City of Portland, Maine - Building or Use Permit Application
 389 Congress Street, 04101 Tel: (207) 874-8703, Fax: (207) 874-8716

Permit No: 04-1545	Issue Date:	CBL: 336 E070001
------------------------------	--------------------	----------------------------

Proposed Project Description: Build new 26'x26' 2 car garage w/ family room over	Signature:	Signature:
PEDESTRIAN ACTIVITIES DISTRICT (P.A.D.)		
Action: <input type="checkbox"/> Approved <input type="checkbox"/> Approved w/Condition <input type="checkbox"/> Denied		
Signature:	Date:

**PLOT PLAN / SITE PLAN**  
 FOR PROPOSED 26' x 26'  
 1 1/2 STORY 2 CAR GARAGE  
 ADDITION w/ FULL DORMER -  
 AT 65 BUCA RUN

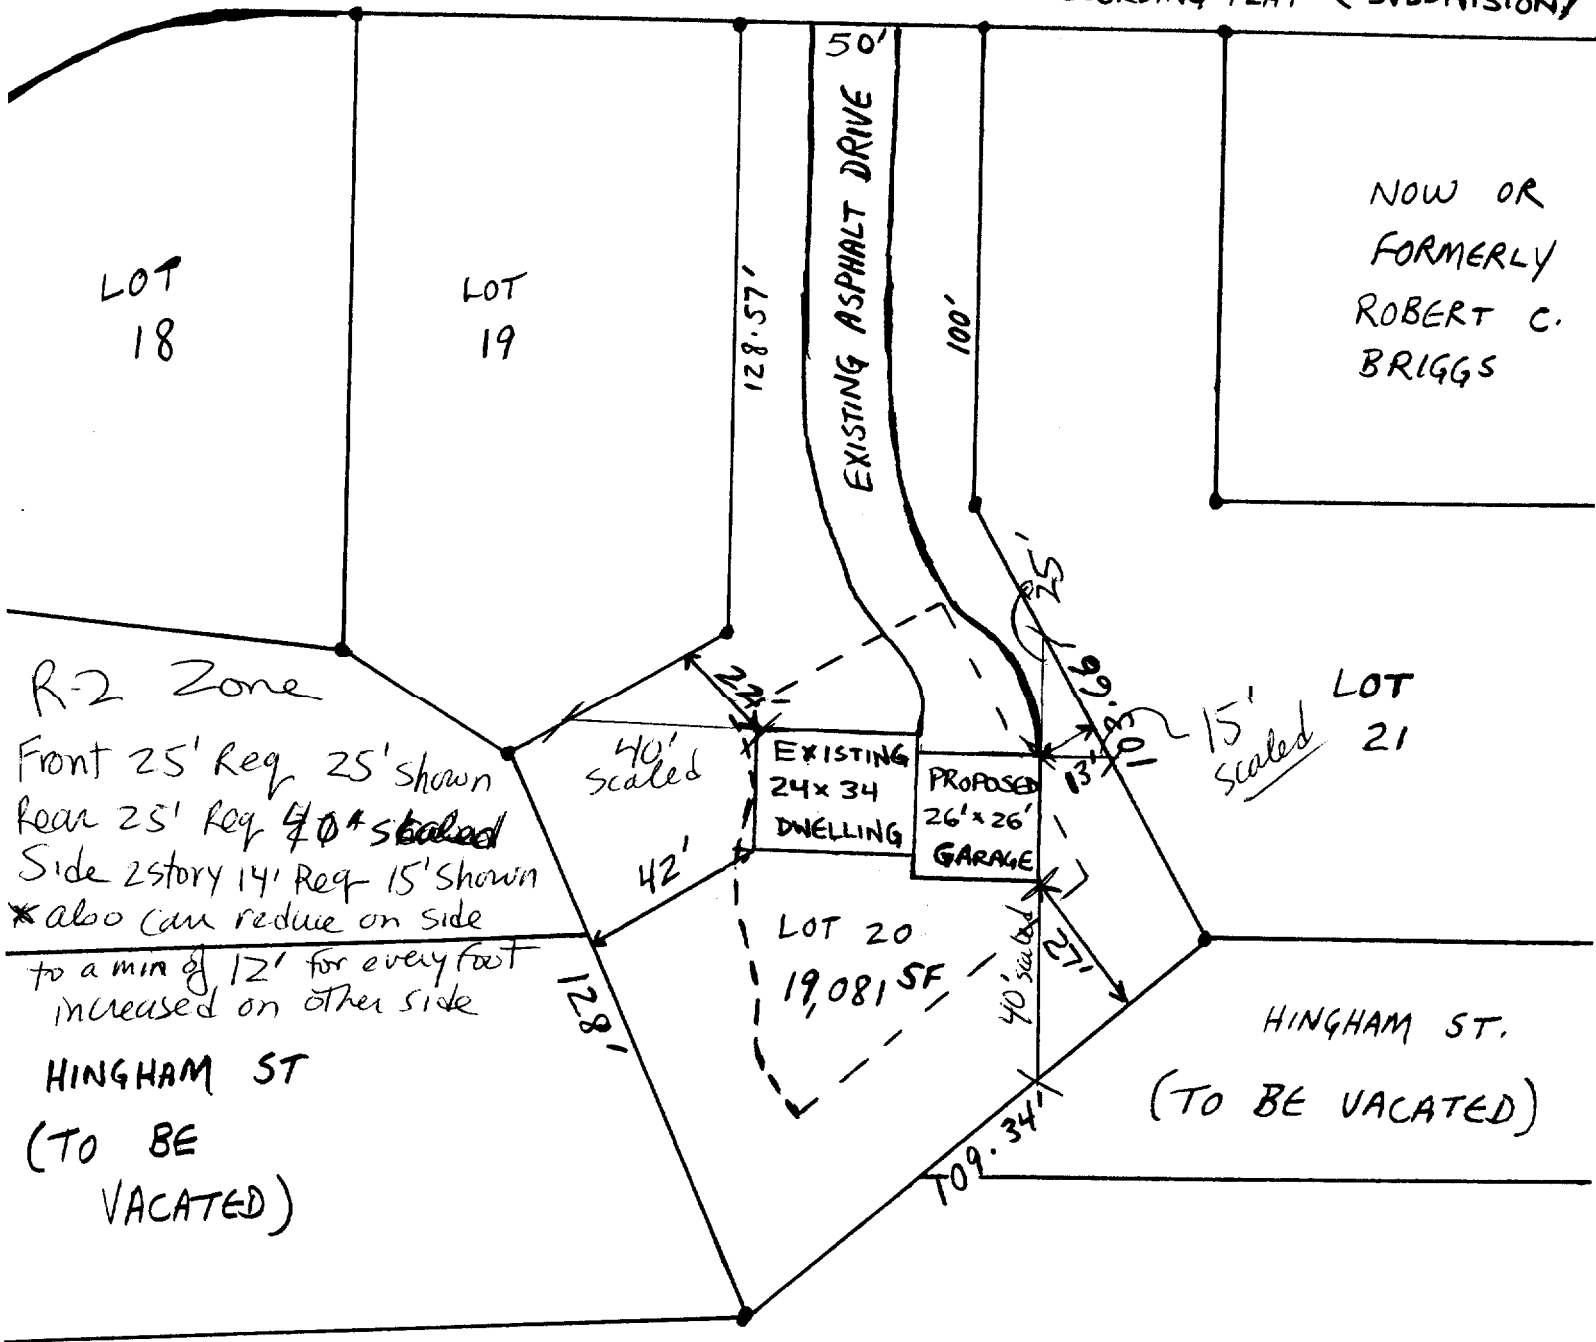
- 1) The full site plan review & fee for this garage was waived by this department and the DRC approved the site plan from the original subdivision with some minor changes.
- 2) As discussed w/Robert M., the front setback is very close to the 25' requirement. A survey may be required to verify compliance with the code.
- 3) This property shall remain a single family dwelling. Any change of use shall require a separate permit application for review and approval.
